AL-18-027

## SPECIAL USE NEWCOMB EXTENDED FAMILY

A request by Janice Newcomb for approval of a special use for a guest house with special provisions for extended family housing. The property is zoned RR-5 (Residential Rural) and is located on the northwest side of Preston Place, approximately 553 feet north of the intersection of Tracy Lane and Preston Place. The property is located within the Falcon/Peyton small area master plan. (Parcel No. 42130-01-016) (Commissioner District 2) (Len Kendall)  
**Type of Hearing: Quasi-Judicial**

VARIANCE SPECIAL
USE
ZONE R3
DATE: 1-3-93
OWN BY BILL MOORE
B/M CONST.

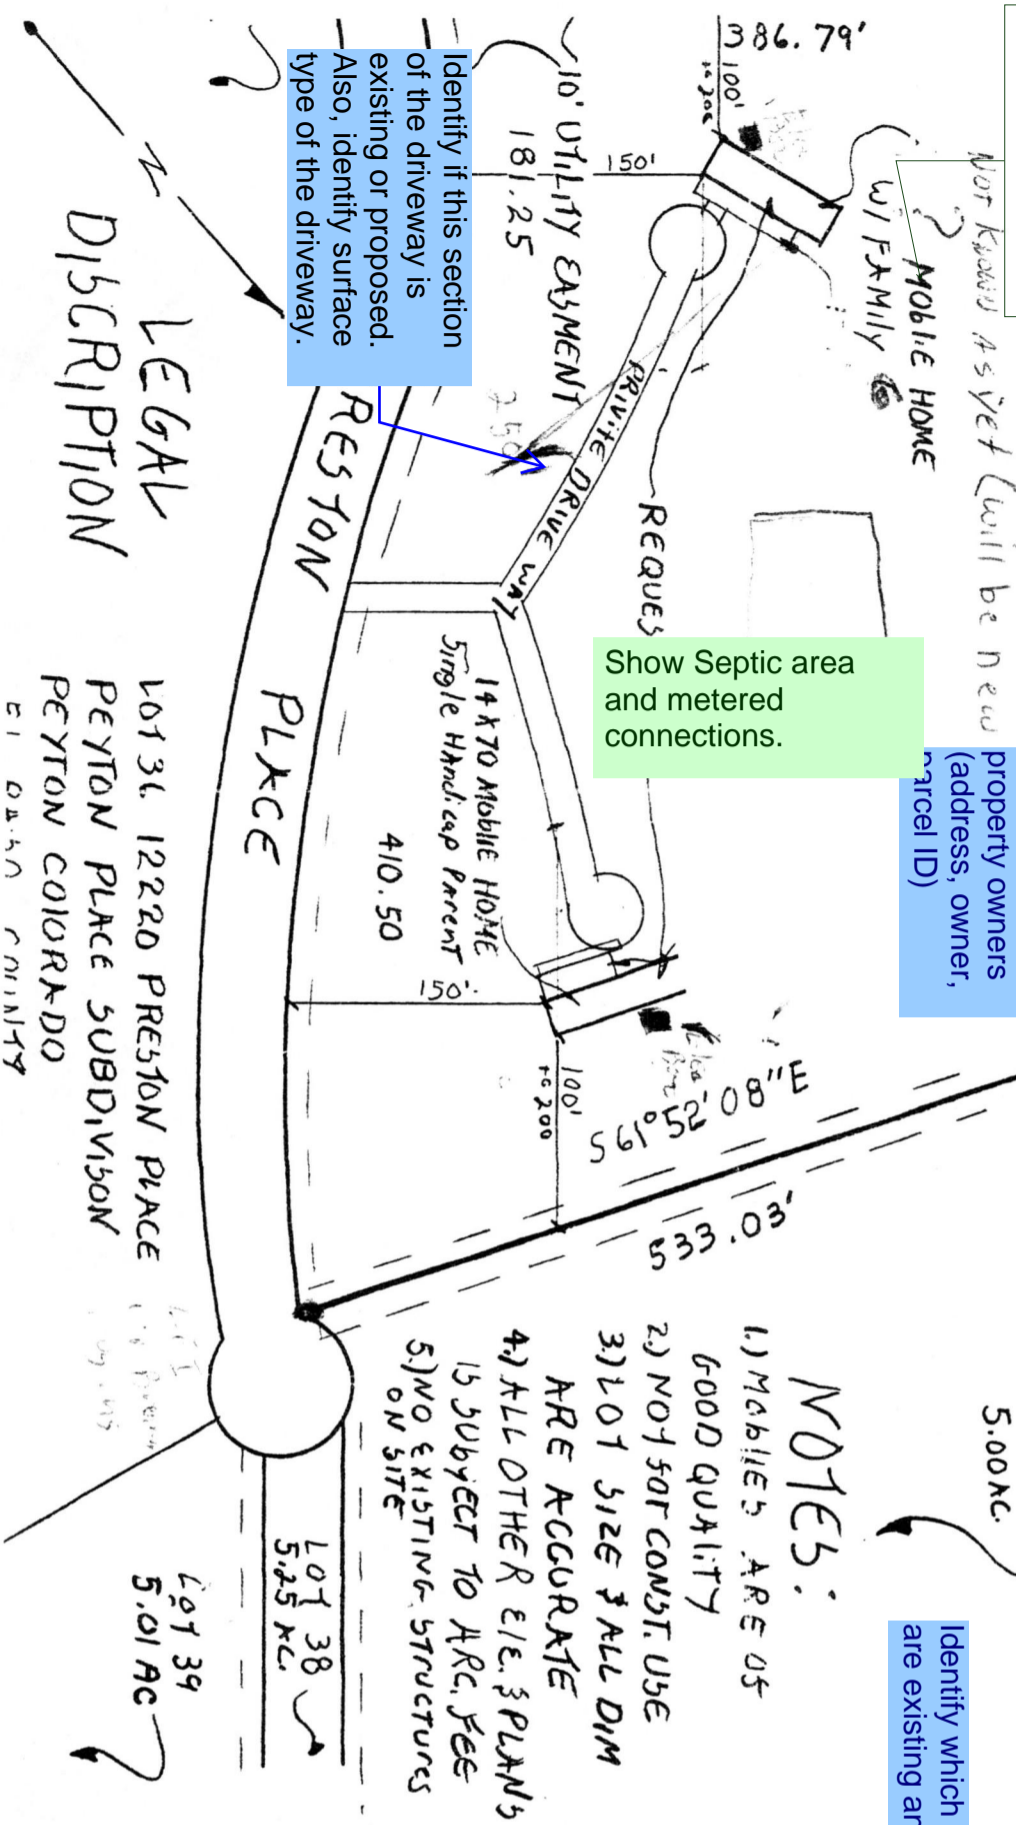
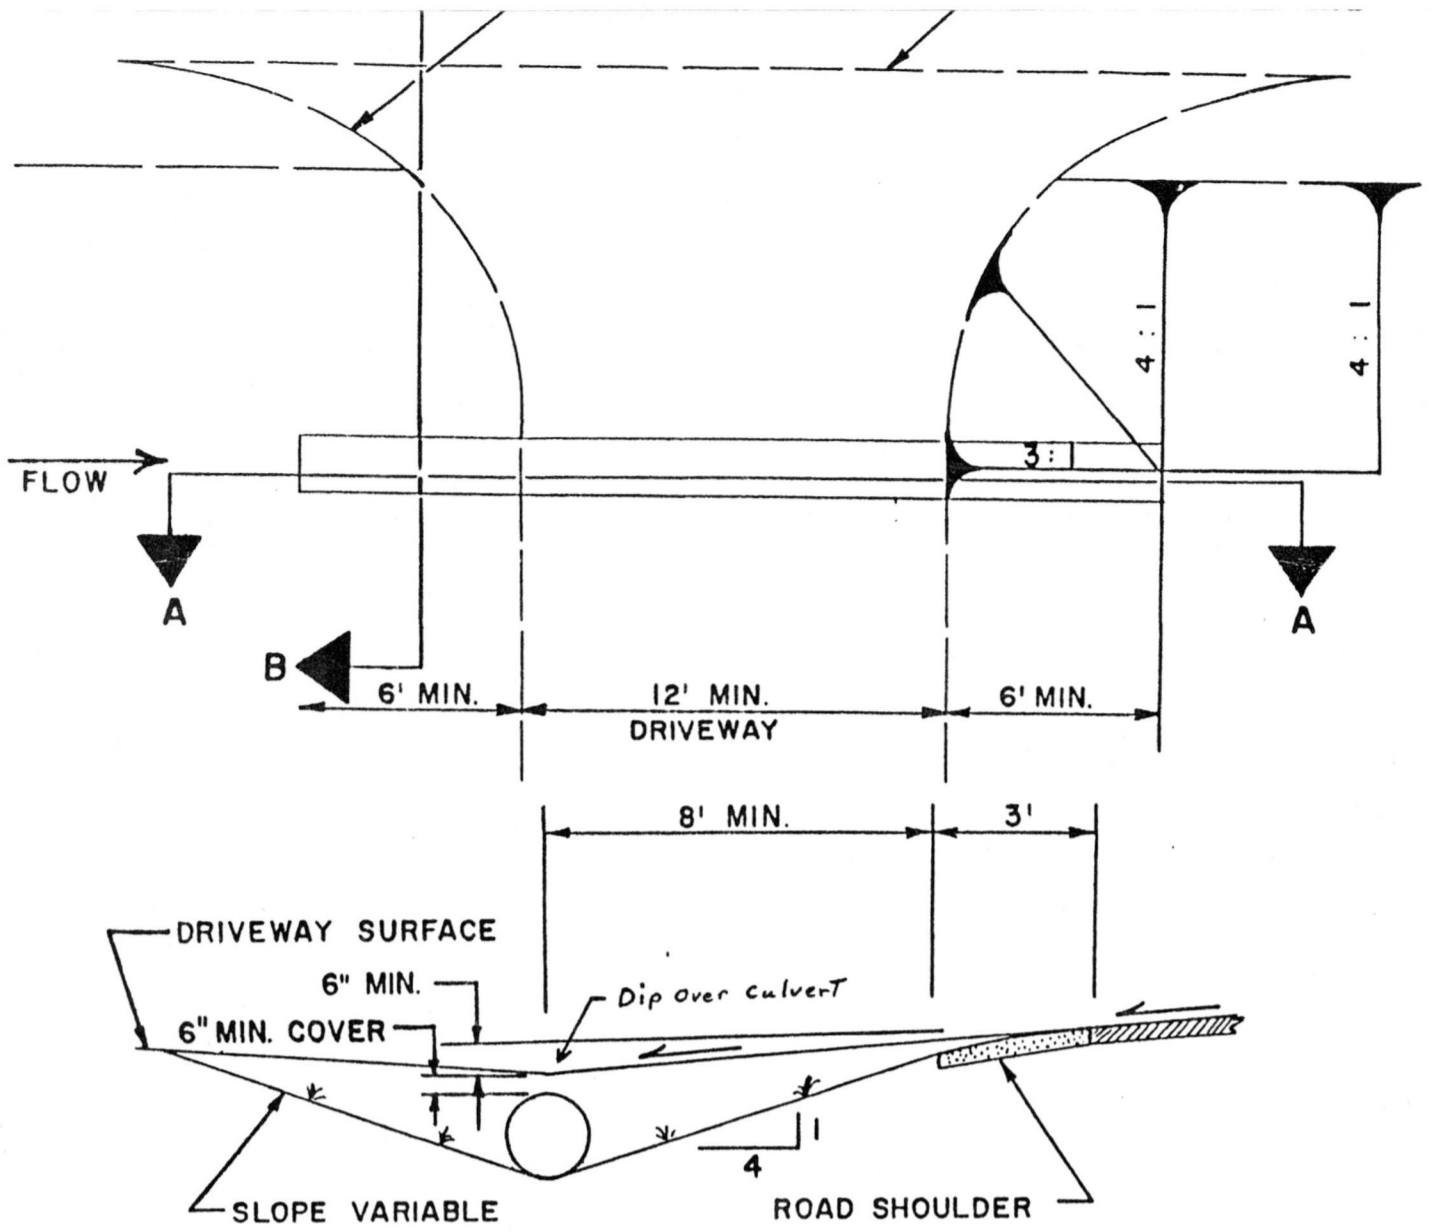
8. Site plan, is not correct and setback requirements stated on Site Plan, on garage, need to be proven and re-checked due the the measurements, stated on Site Plan. In my review, the layout, was copied of another Site Plan in the database. "Bellville Extended Family" because their easements, were added to Newcombs site plan, They do not have the easements, as indicated. Now; this has been brought forward to Lopez and Elliotts, where they have shared, vested interest. This is irritating, to review the many errors, being presented, without any Professional involved.
